To: South Holland District Council Application Ref: H19-1174-25

Proposal: Proposed Pair of Semi Detached Houses

Location: **Land north of 291 Broadgate Road, Sutton St Edmund, Spalding, Lincolnshire PE12 0LR**

ADDITIONAL INFORMATION REQUIRED

Site Plan 1:200

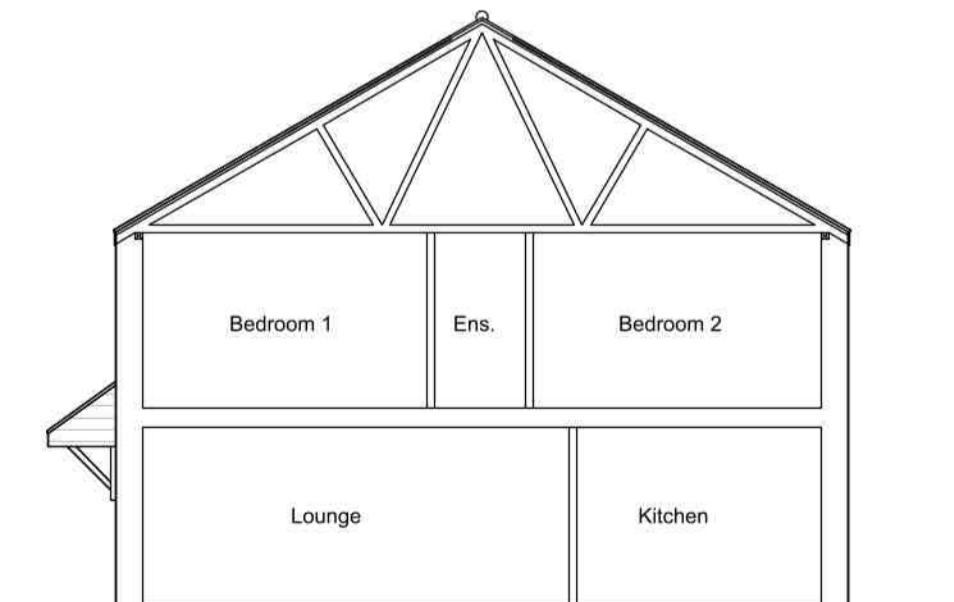
A shared access should be a minimum of 4.1m wide.

At the highway boundary the height of the proposed fence shall not exceed 0.6m so as not to obscure the visibility splay.

The Access note is to read to Lincolnshire County Councils specification.
